KIRKLEES METROPOLITAN COUNCIL INVESTMENT & REGENERATION SERVICE

DELEGATED DECISION TO DETERMINE PLANNING APPLICATIONS

Reference No:	2023/62/92461/E
Site Address:	Four Winds, 2, Highbridge Lane, Skelmanthorpe, Huddersfield, HD8 9JY
Description:	Erection of extension and alterations
Recommending Officer:	Elenya Jackson

DECISION – REFUSE

title **General Arrangement as Proposed**
number **22014D-03-P03**
scale **1:100 / 1:200**
size **A1**

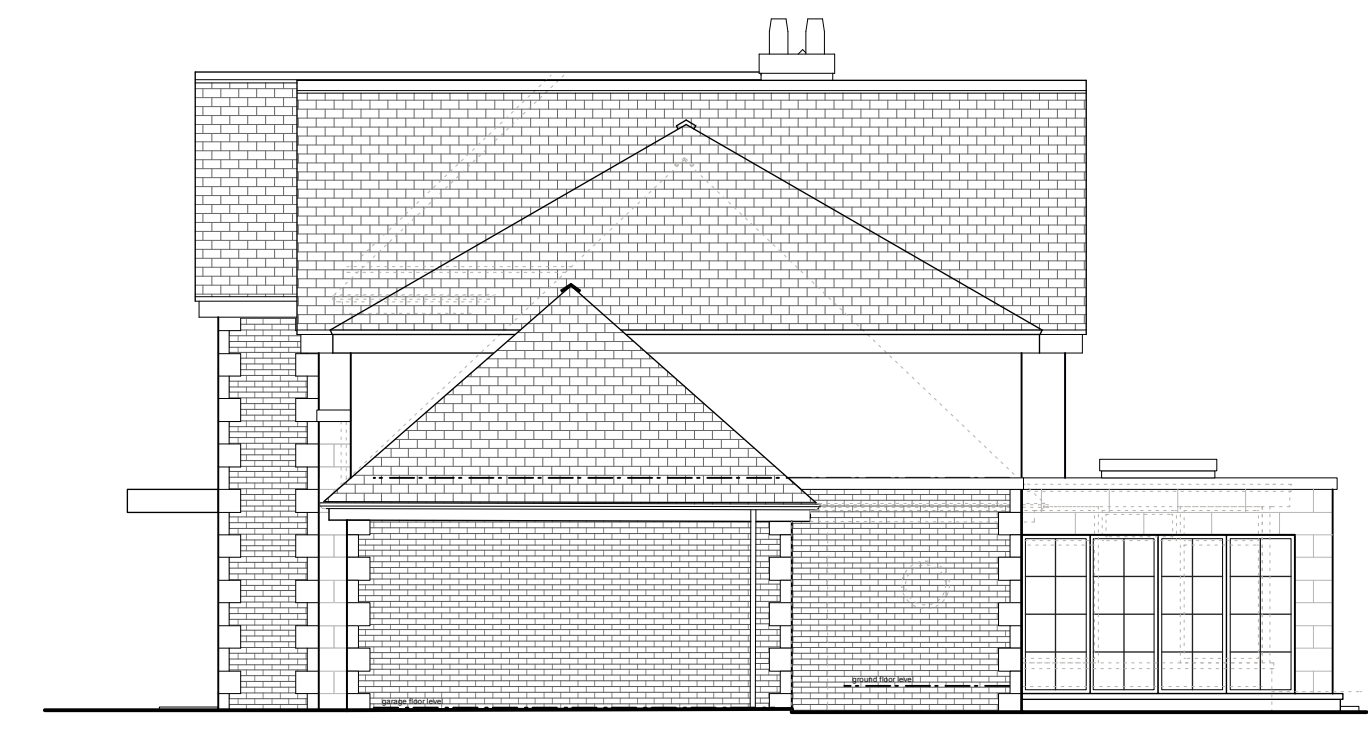
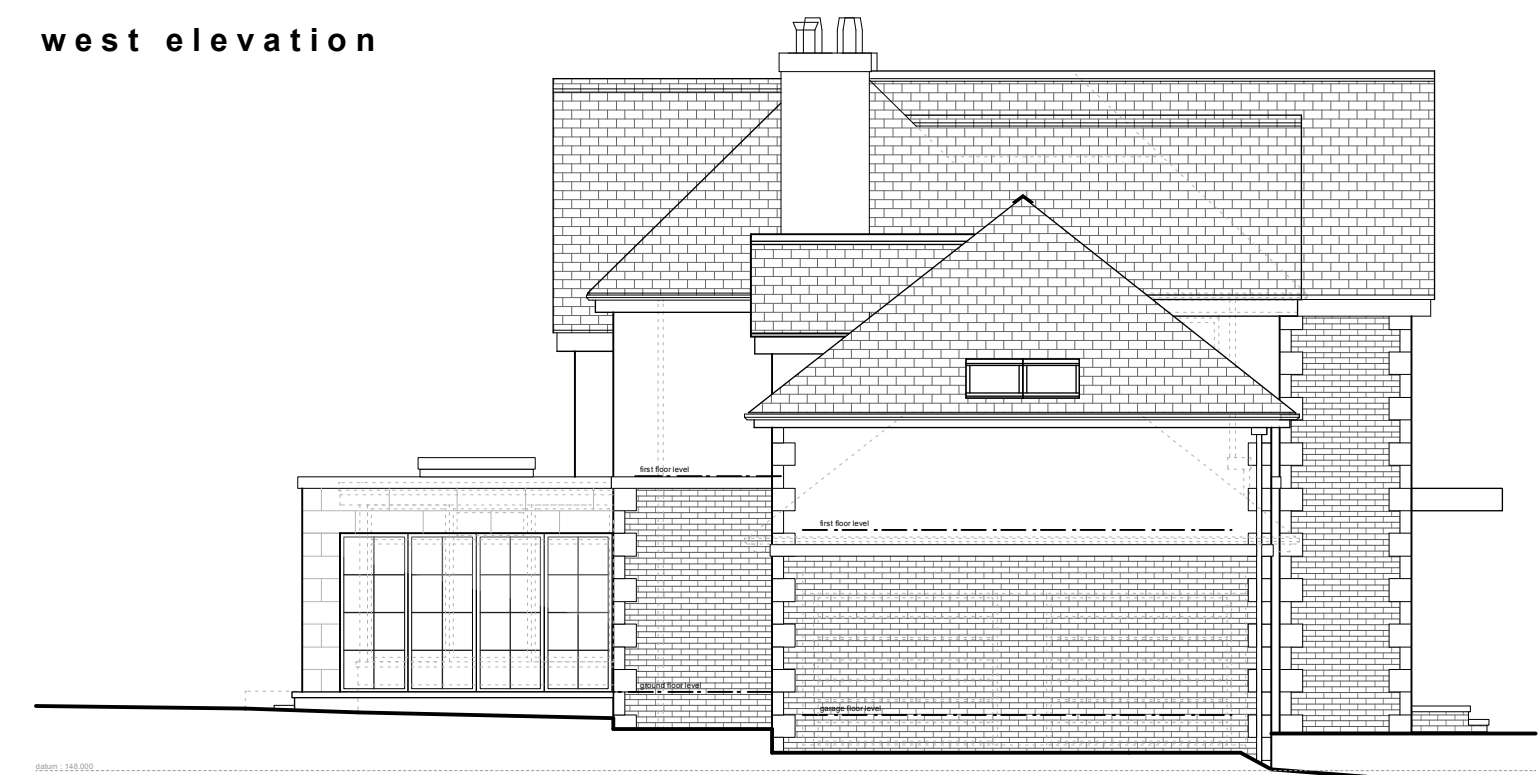
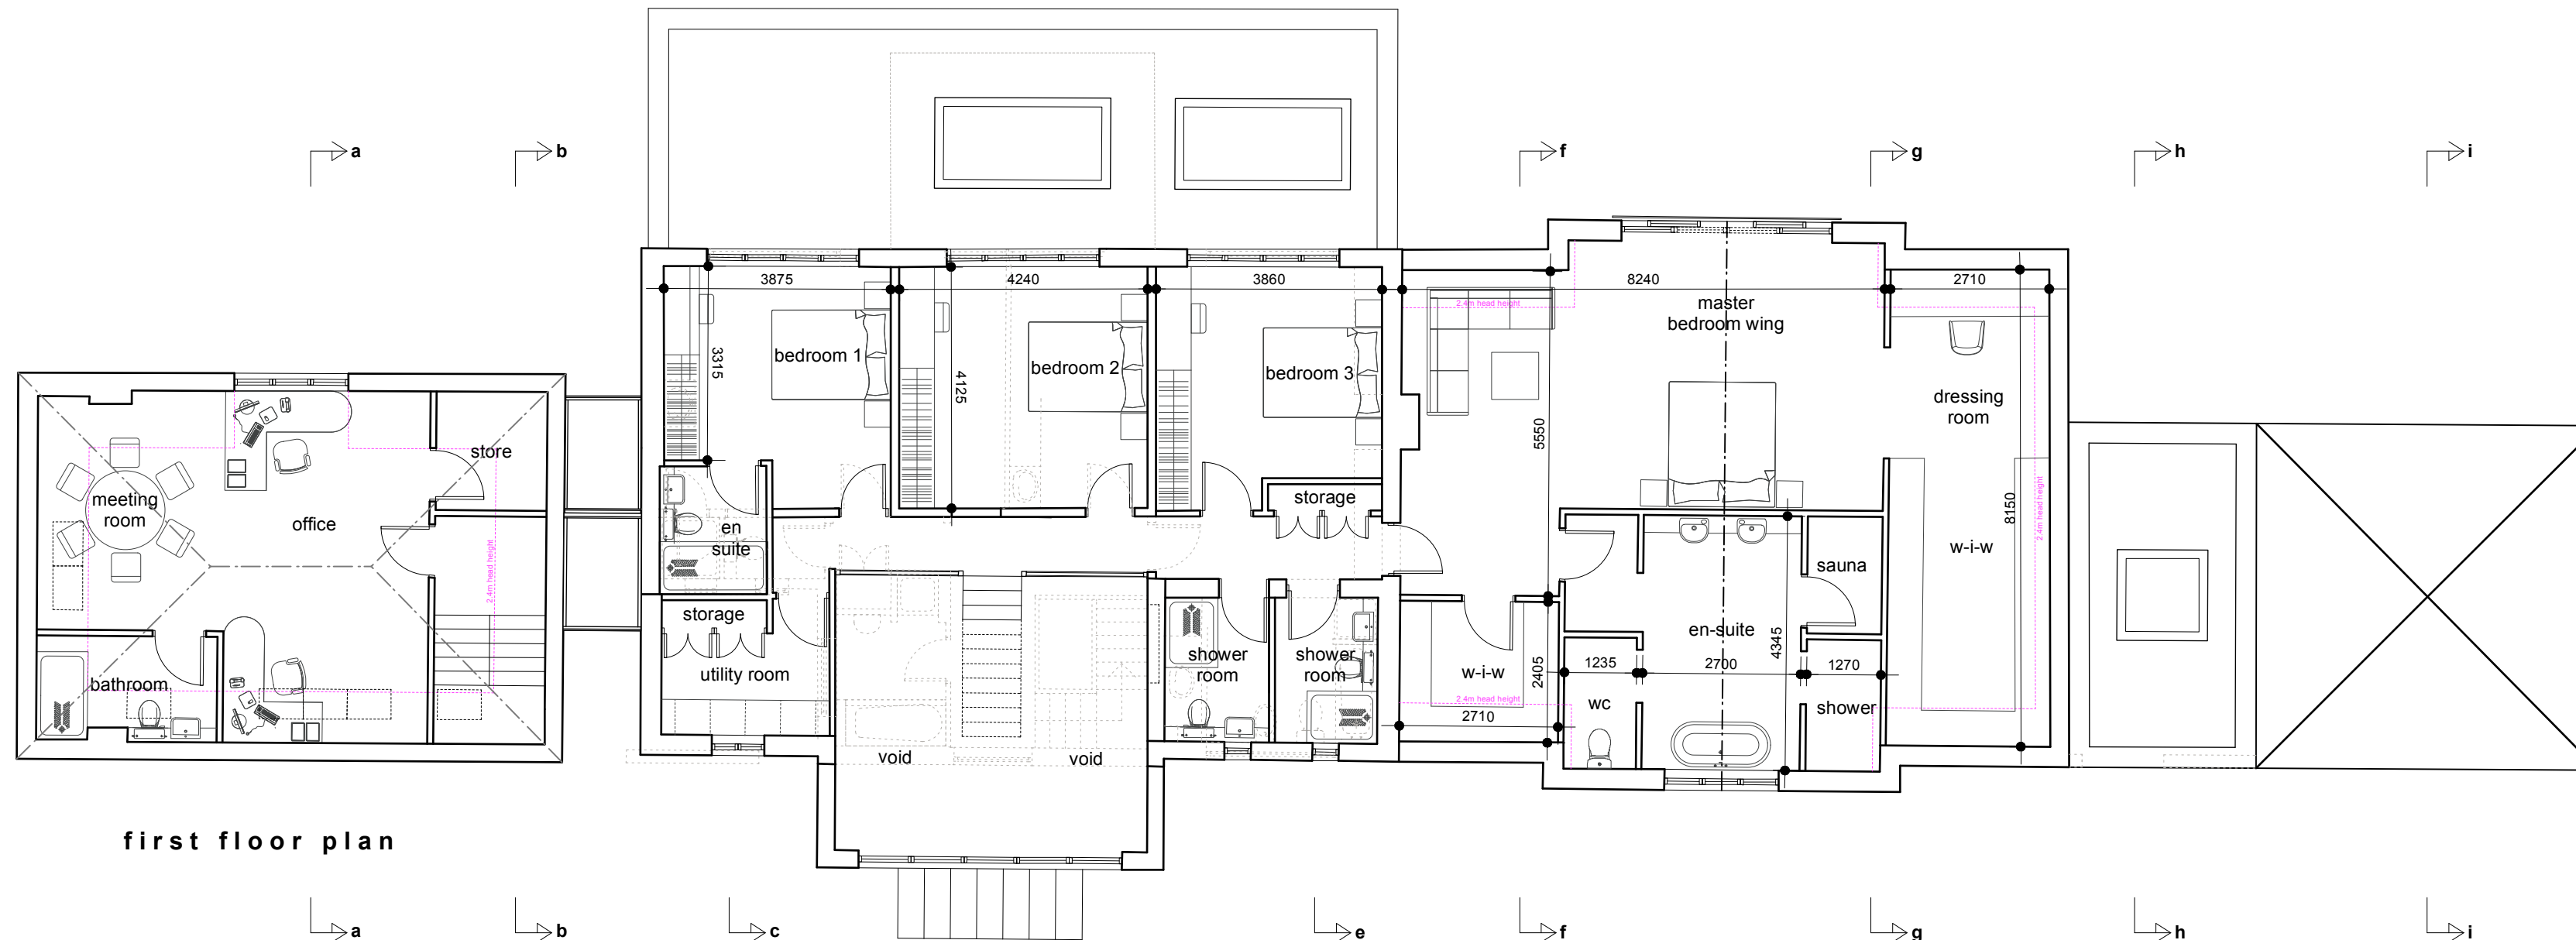
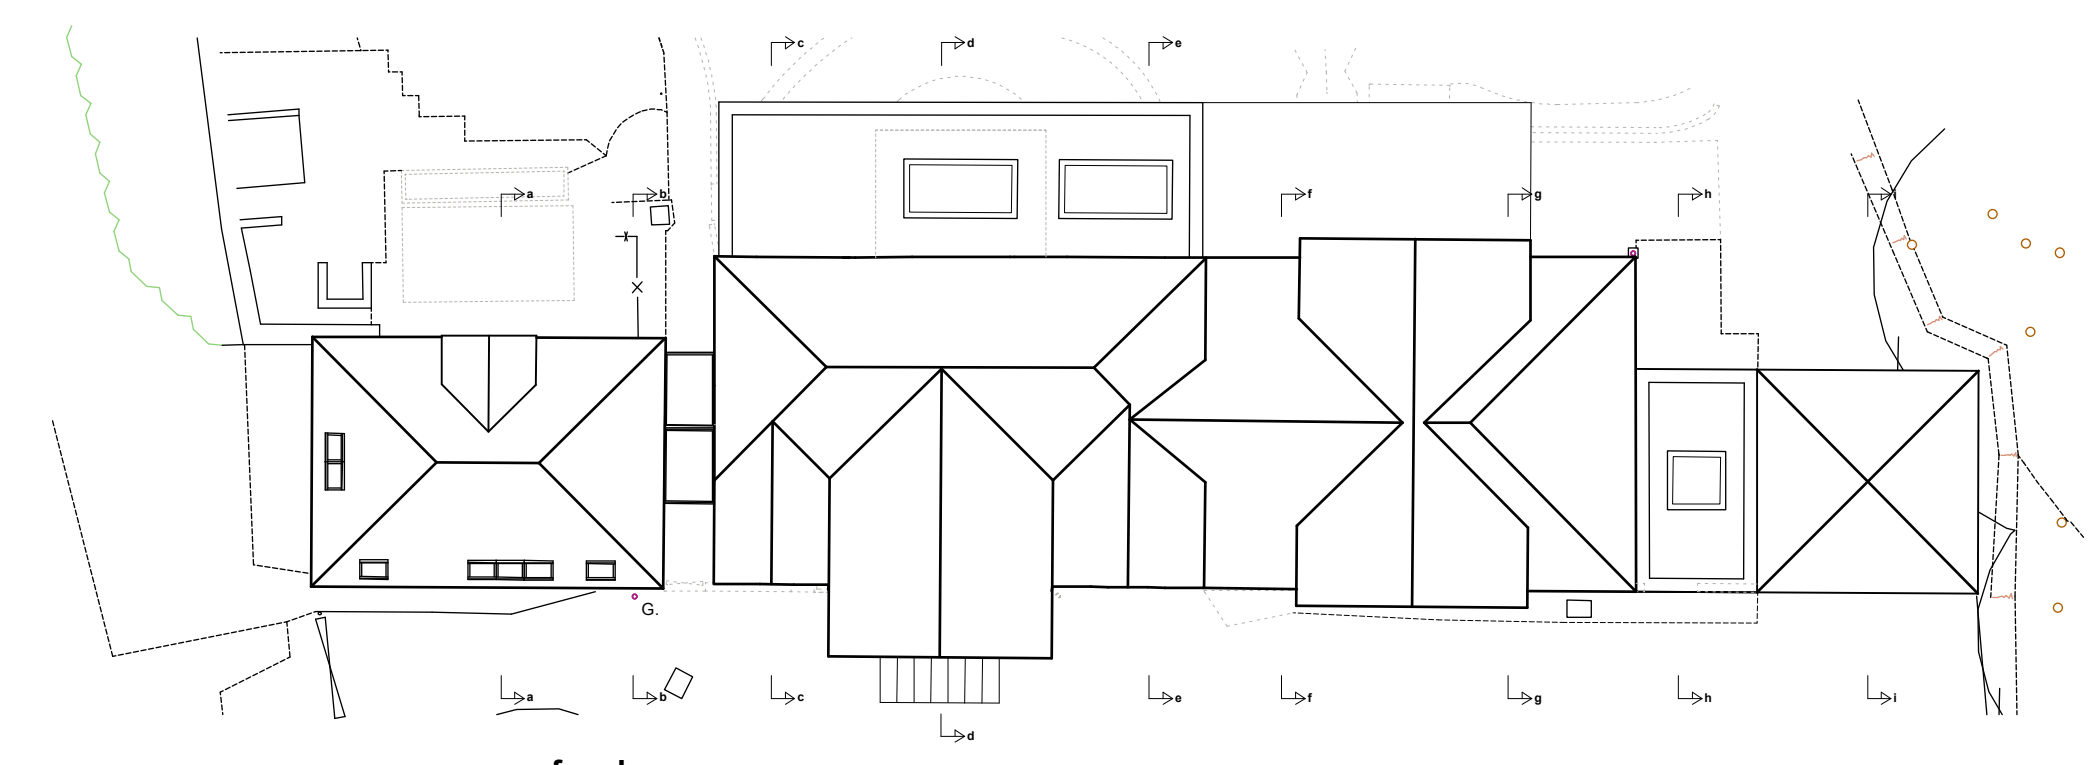
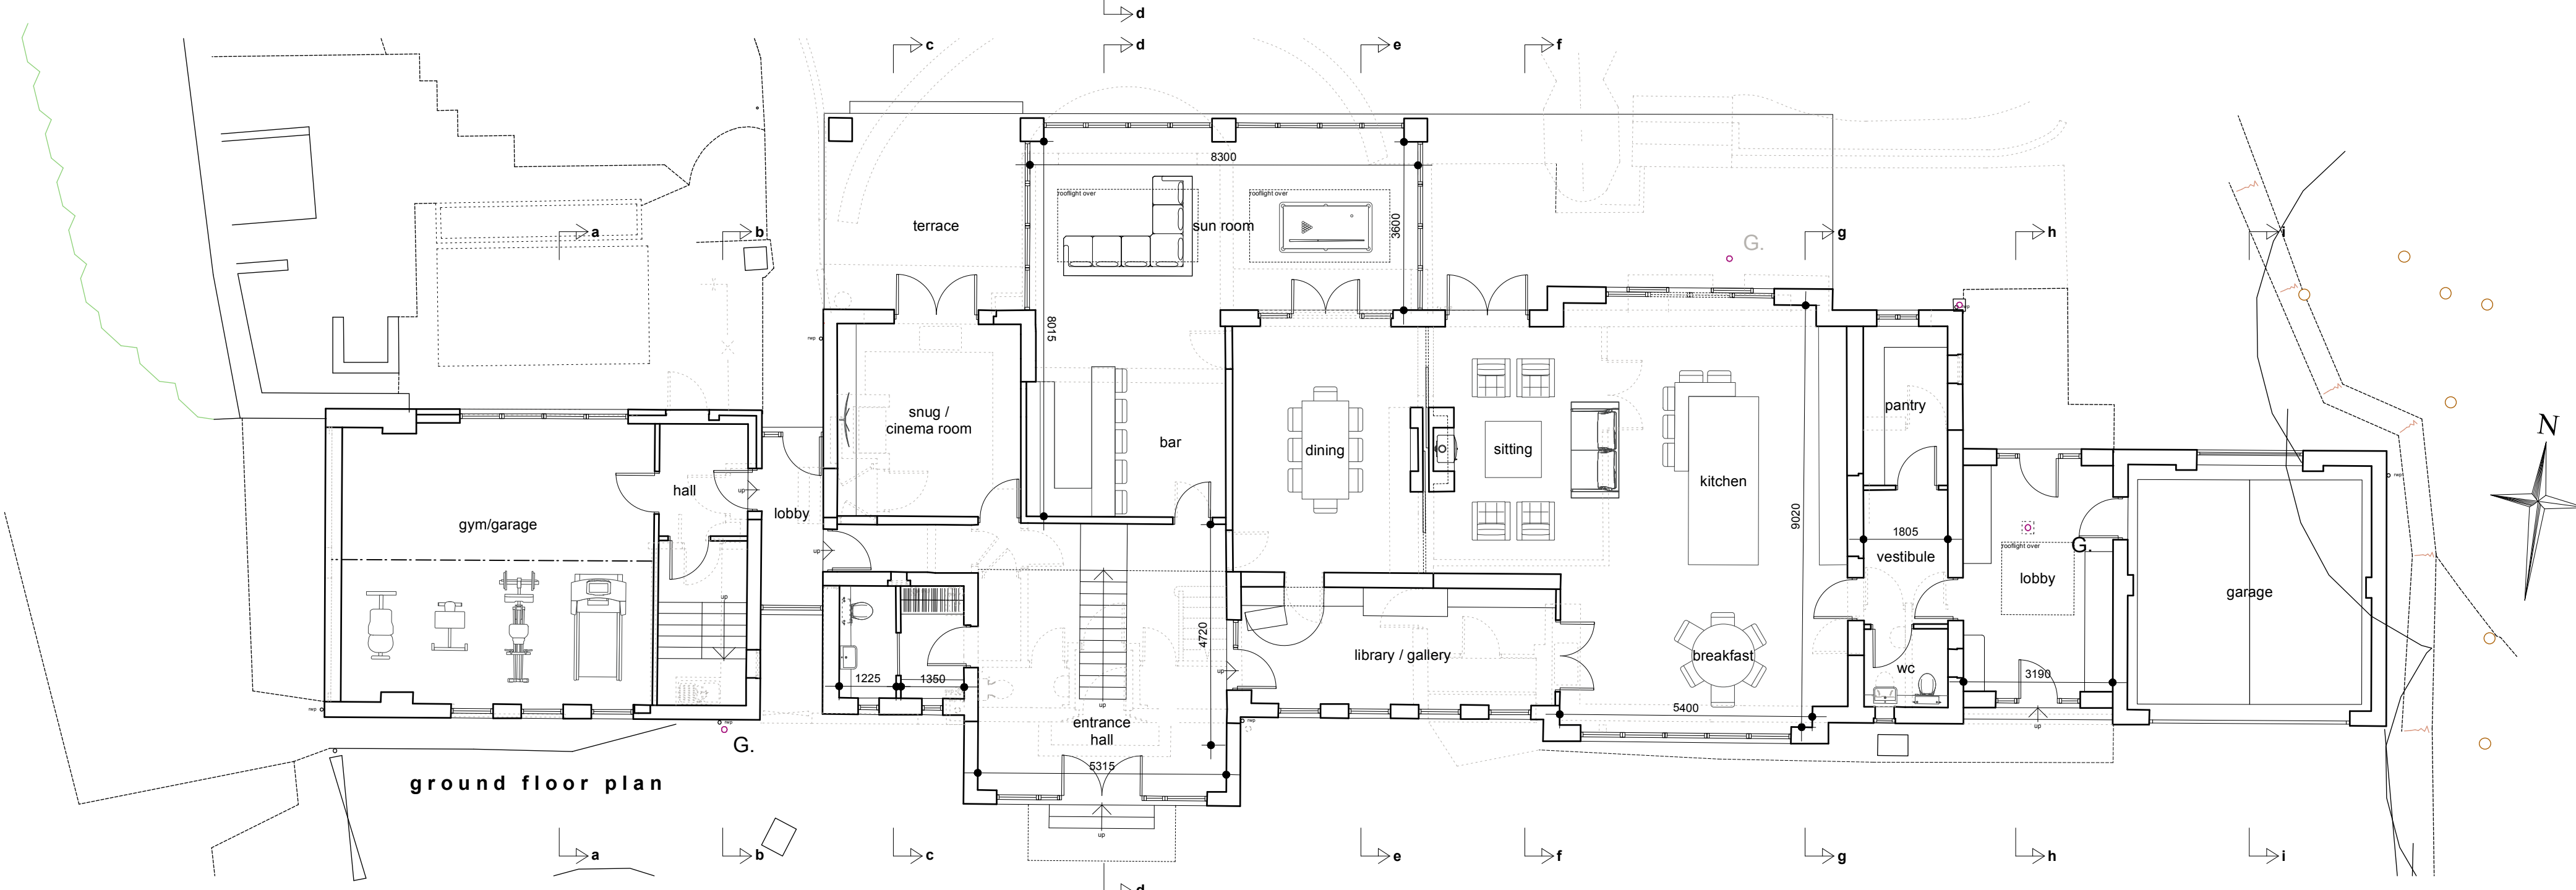
The existing dwelling has width of 43.9m and the proposal would have a width at ground floor level of 4.4m. From reviewing the plans, it appears this increase in width is related to the gym/garage.

There would be an infill extension to form a lobby between the existing garage and the main dwelling. This would feature a flat roof with a maximum height of 2.9m and a depth of 5.9m.

The proposal would add a first floor to the previously approved single storey side extension and introduce a two storey gable end to the principal elevation of the dwelling. The proposal would increase the eaves height by 2.3m to 4.8m.

The gable end to the rear would have a maximum height of 8.3m.

The proposal would amend the existing principal elevation to feature a fully glazed gable end which would project 1.8m beyond the principal elevation of the dwelling.

There would be a gable end either side which would have a maximum height of 8.1m.

The proposed side extension would have a 48cm projection to the north and south elevation to enable the construction of a two storey gable ends with a maximum height of 8.3m with an eaves height of 5m (increased from 2.8m).

The existing garage would also feature the introduction of a first floor which would increase the eaves height of the proposal from 3.1m to 4.7m and the overall height of the garage from 6m to 7.6m.

The proposal would also include the construction of a single storey rear extension and a terrace which would extend 4m beyond the rear elevation of the existing dwelling and have a width of 8.7m,

In this particular case, when taking into consideration the scale of the proposed alterations (including the previously approved alterations on site), the proposed development would have a footprint at ground floor level of 387.6m² which does not include associated hardstanding and rear terrace. This would represent a 246m² increase at ground floor level from the original planning unit.

The first floor of the property originally had a footprint of 112m² and would increase to 229m² for the main dwelling and 61.8m² above the workshop which officers have been unable to locate a previous permission for. This would represent a 158.9% increase to the first floor footprint of the dwelling.

The combination of the first floor and ground floor additions to the proposal would result in cumulative development on site amounting to 678.4m² across both floors. As the original dwelling was two storeys with a footprint of 112m², this would represent a 505.7% increase to the footprint of the dwelling.

Subsequently, the overall volume of the dwelling would be substantially increased, and the proposal would result in disproportionate additions over and above the size of the original building. It is therefore considered that the proposals impact on the openness of the Green Belt, both spatially and visually, is considered to be unacceptable.

It is the case that the original building has already been substantially extended and the proposal would result in significant and disproportionate additions over and above the original dwelling. The proposal would therefore fail to comply with Policy LP57(a) of the Kirklees Local Plan and the aims of Chapter 13 of the NPPF as the original house would not remain the dominant element. In addition to the above, it is considered that the increased sense of scale created by the increase to the maximum height of the proposal, coupled with the introduction of two storey gable ends and roof alterations would result in an overly vertical emphasis/contrast with the existing development. The proposal would subsequently result in the application dwelling appearing incongruous in the context of the host dwelling.

The proposal would fail to comply with Policy LP24 of the Kirklees Local Plan (a) in terms of the form, scale and layout and (c) as the extension would not form a subservient addition to the property in keeping with the existing building; nor advice within the House Extensions and Alterations SPD, specifically KDP1 with respect Local Character, taking into account the rural local area. In addition, the proposal would not accord with KDP2 with regards to the impact on the original house as the design of the extensions is neither well balanced, proportionate or sympathetic to the existing house or the aims of chapter 12 and 13 of the National Planning Policy Framework

1. The proposed extensions, taking into account earlier extensions to the dwelling, would be disproportionately large in relation to the original part of the building and represent inappropriate development, which is harmful to the Green Belt and the visual amenity of the area. The proposed development is therefore contrary to Policy LP57 of

1. The proposed extensions, by virtue of their scale and design, would not be subservient to the original dwelling and would detract from the character and appearance of the dwelling. To permit the proposals would be contrary to policies LP24 and LP57 of the Kirklees Local Plan, advice within the House Extensions and Alterations SPD and Chapters 12 & 13 of the National Planning Policy Framework.
